STATE OF NORTH CAROLINA
DEPARTMENT OF TRANSPORTATION

Addendum No. 1

RE: Contract ID C202448

Guilford County (U-5157B)

MAP 1 STA. 000+00 TO STA. 165+40  
MAP 4 STA. 131+00 TO STA. 221+16  
MAP 8 STA. 018+00 TO STA. 084+80  
**TYPICAL SECTION NO. 1**

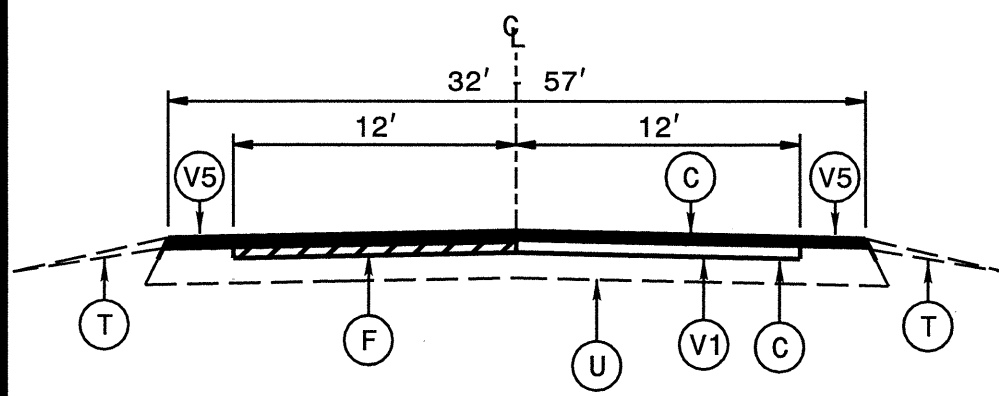
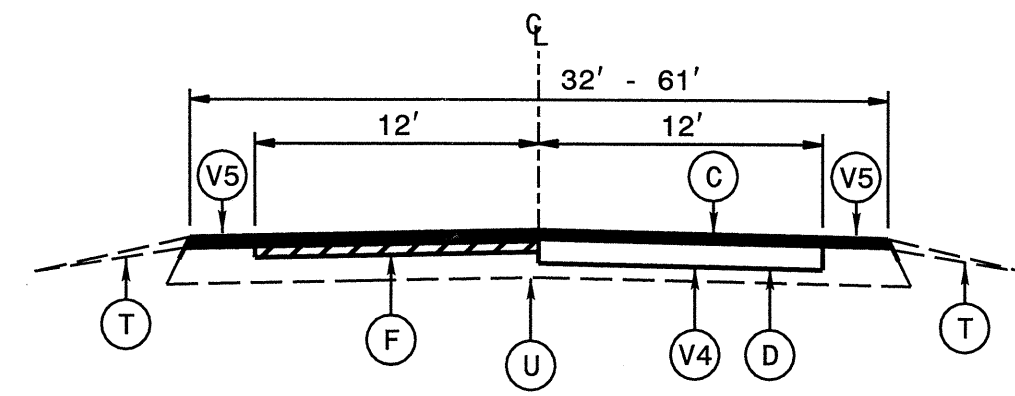
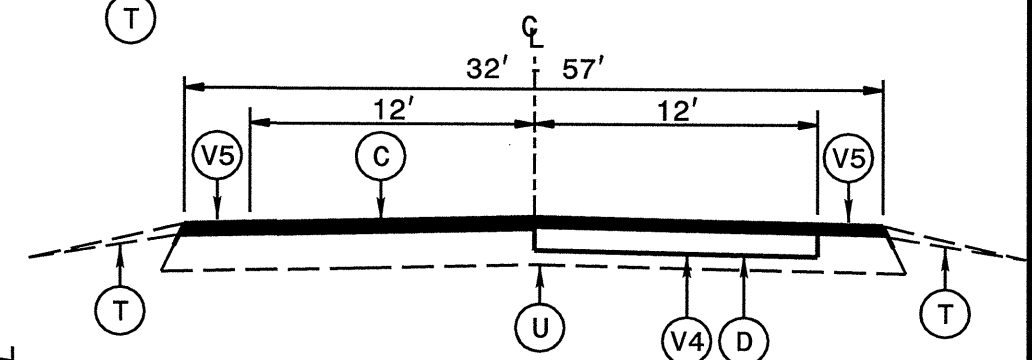
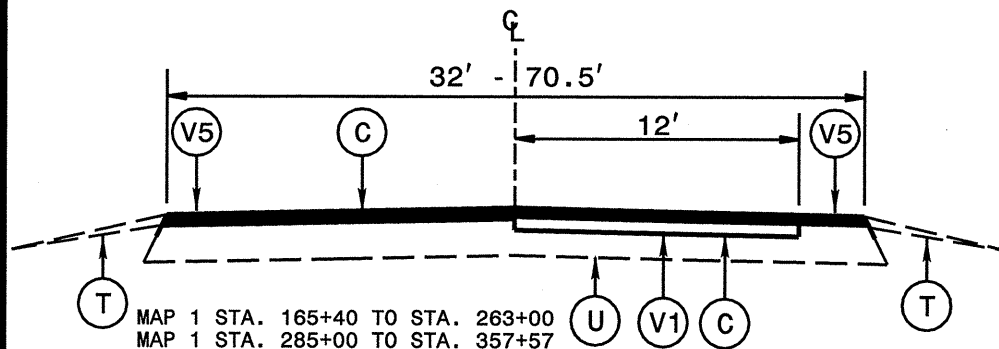
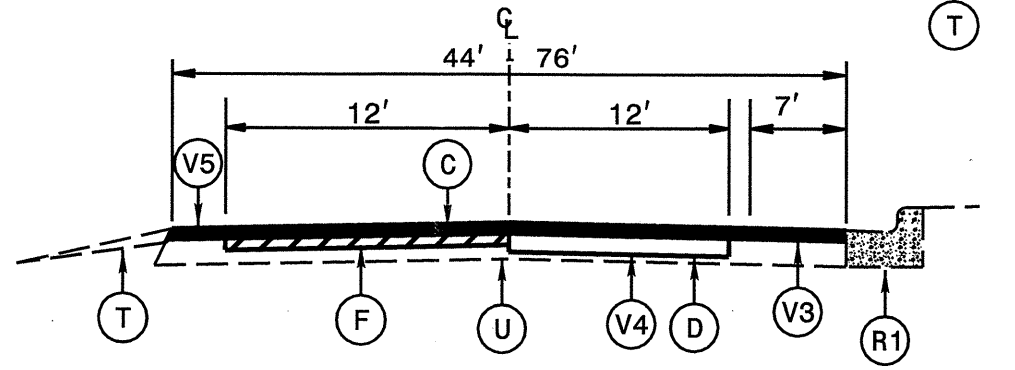
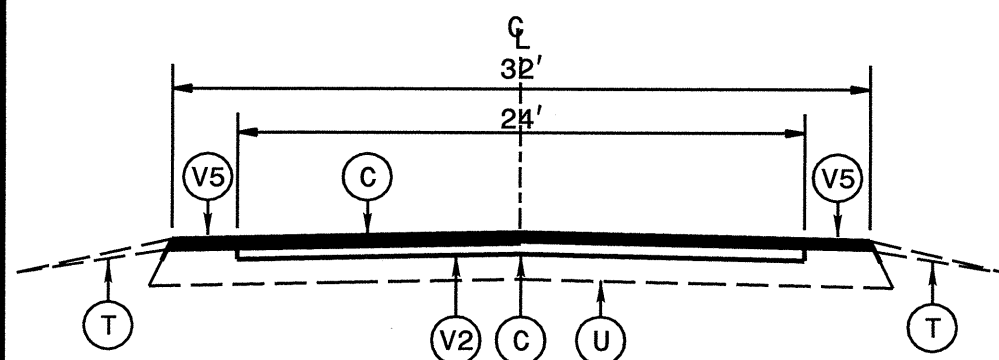
The typical sections and Summary of Quantities have been revised to reflect the above noted changes.

On Page No. 1 of the item sheets, by copy of this addendum the quantity for line item "9-1523000000-E-610 Asphalt Concrete Surface Course, Type S9.5C" has been decreased from 46,542 TON to 45,572 TON. Also on Page No. 1 of the item sheets, the quantity for line item "11-1565000000-E-620 Asphalt Binder For Plant Mix, Grade PG 70-22 has been decreased from 2,795 TON to 2,738 TON. The Contractor's bid must be based on these revised pay item quantities. The contract will be prepared accordingly.
